Address: Chestnut View, 1B Wood Street Huddersfield Hd8 9bn

Application number: 2021/94397	
What is the application for?:	Certificate of lawfulness for proposed erection of rear dormer
Address of the site or building:	34a, Huddersfield Road, Skelmanthorpe, Huddersfield, HD8 9AS
Postcode:	HD8 9AS

FLOOR PLANS
AS PROPOSED

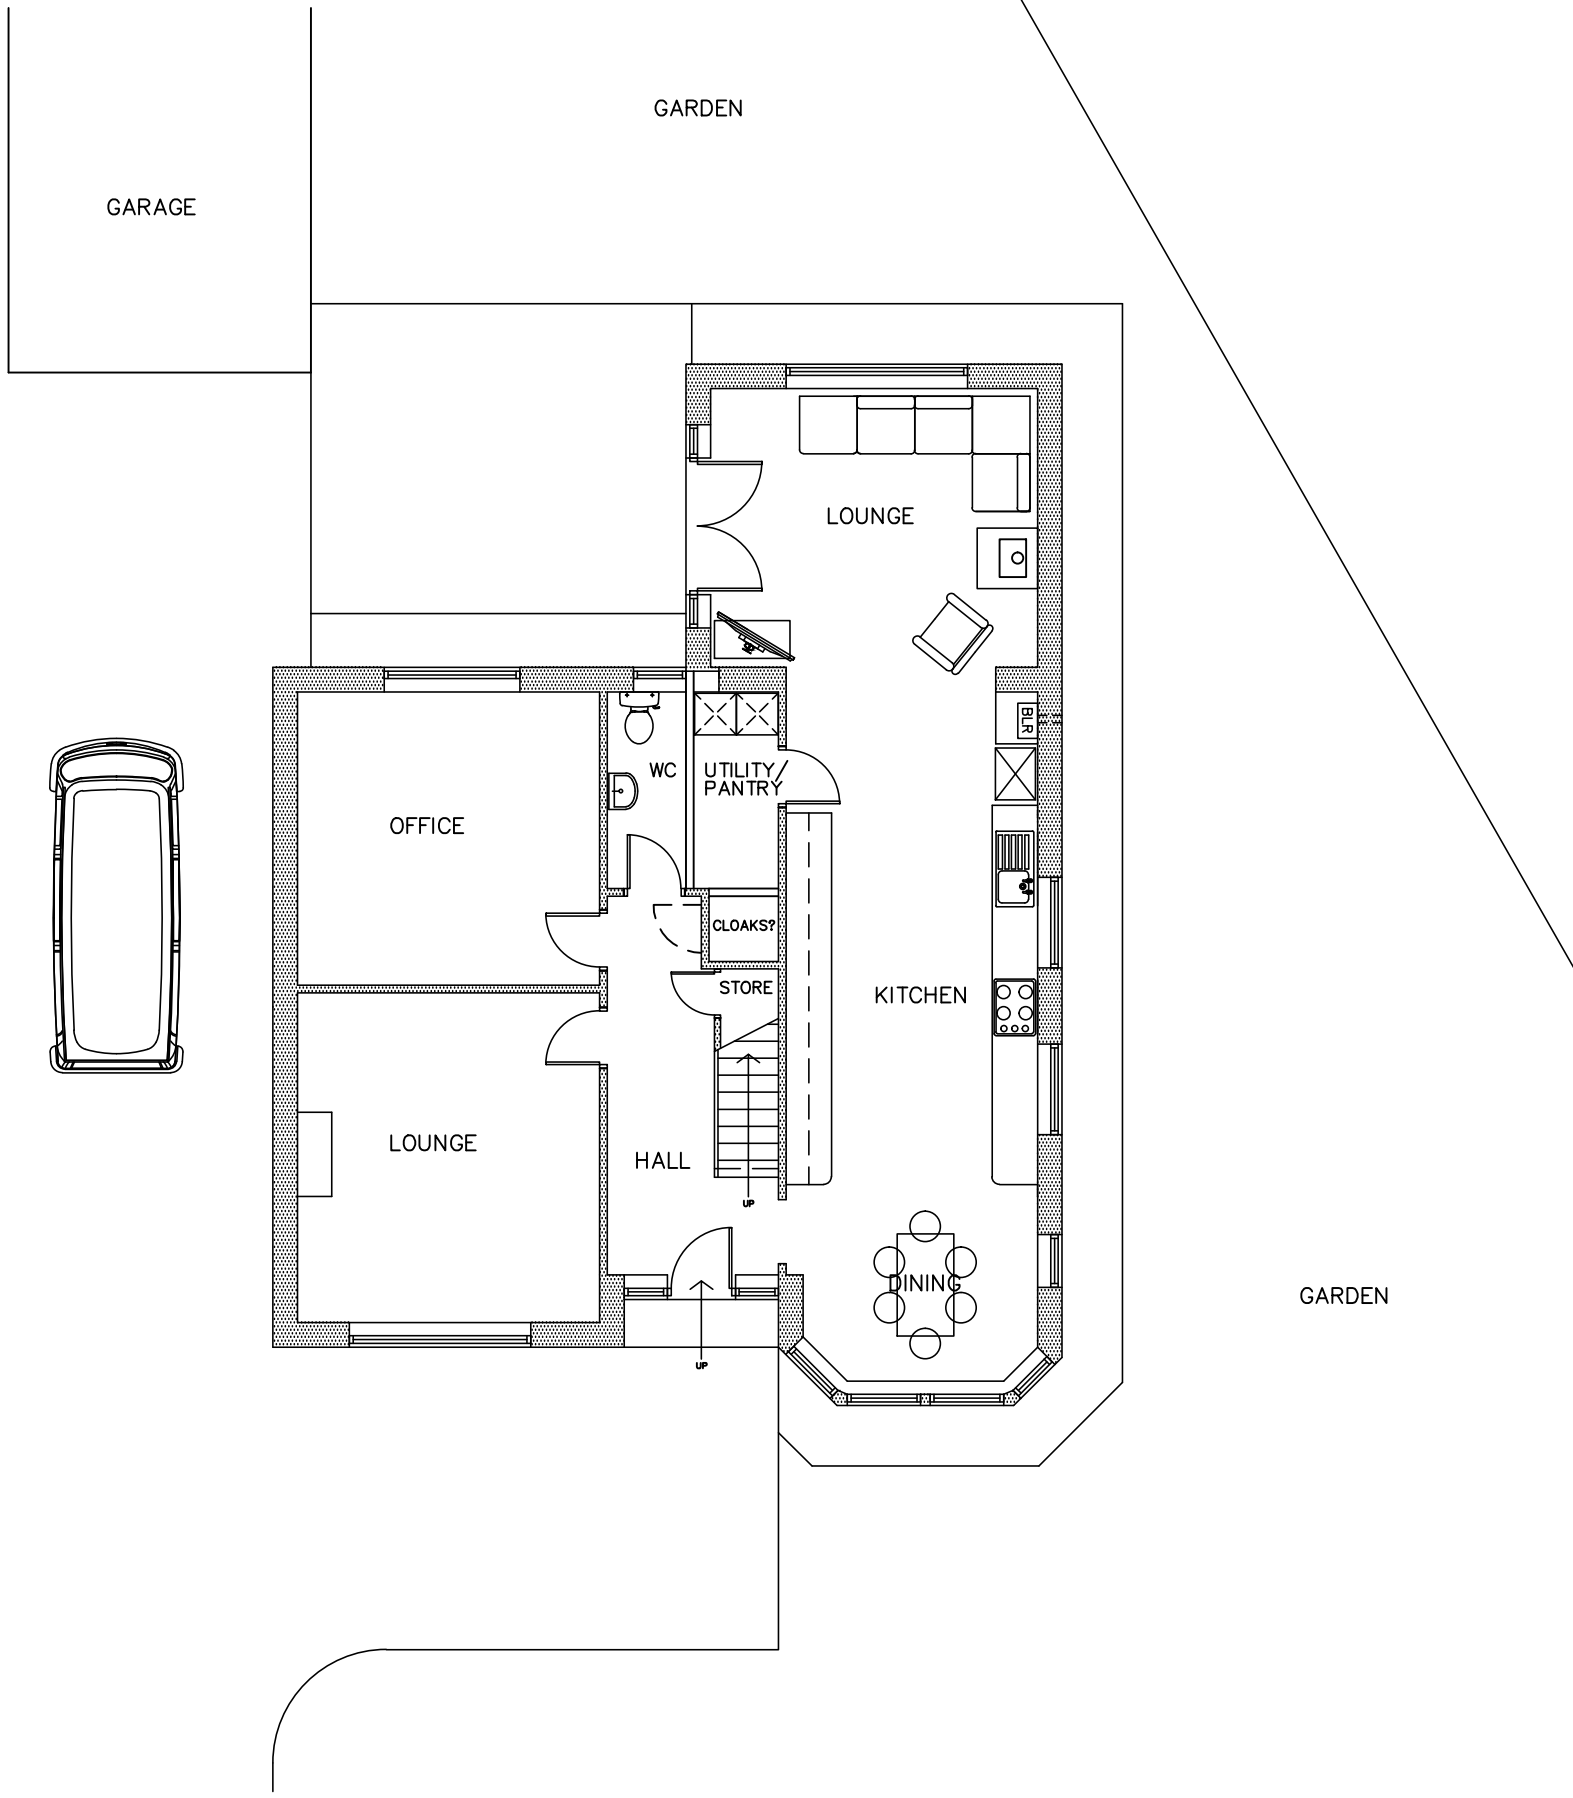
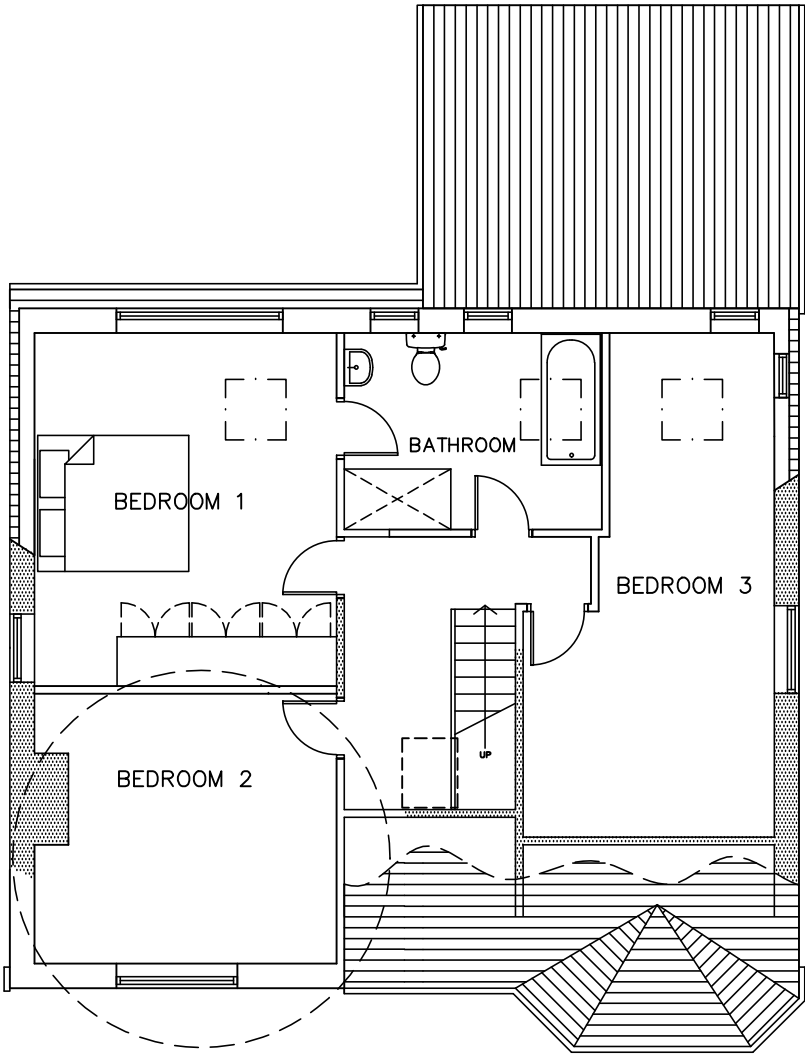
Type of comment: An objection	
Do you wish your comments to be published on the website anonymously?	No
Hi, I write again in reference regarding the above planning application. I have looked at the new plans that have been submitted again and nothing appears to have been changed regarding the dormer bedroom extension windows at the back ,which is going up a level and will overlook directly onto my property and my daughters bedroom and our lounge. As we live directly across from the back of the property / bungalow on Wood street .We are not happy about our privacy and the fact that it is going up a level from being a bungalow ,to a first floor house with a big bedroom window directly overlooking the front of our property (bedrooms and lounge). The bedroom window at the back that I have seen on the plans needs to be taken out or have obscured glass ,as it's way too much of an overlook onto our property and also when the original bungalow was built it was built there and allowed as a one story with velux windows ,as it is too close to be two storey. Also it does obstruct the view over the village that we now have of trees and greenery with making it higher at the back. So I object to this planning that has been put in. Once again I am not happy that the glass on the window is not going to be obscured or the windows reduced on the apex of the first floor extension ,as I have written before and seems to be that there is no consideration to this in any of the new planning information. Could you please reply to this email so I know that you have received my objections. Kind regards
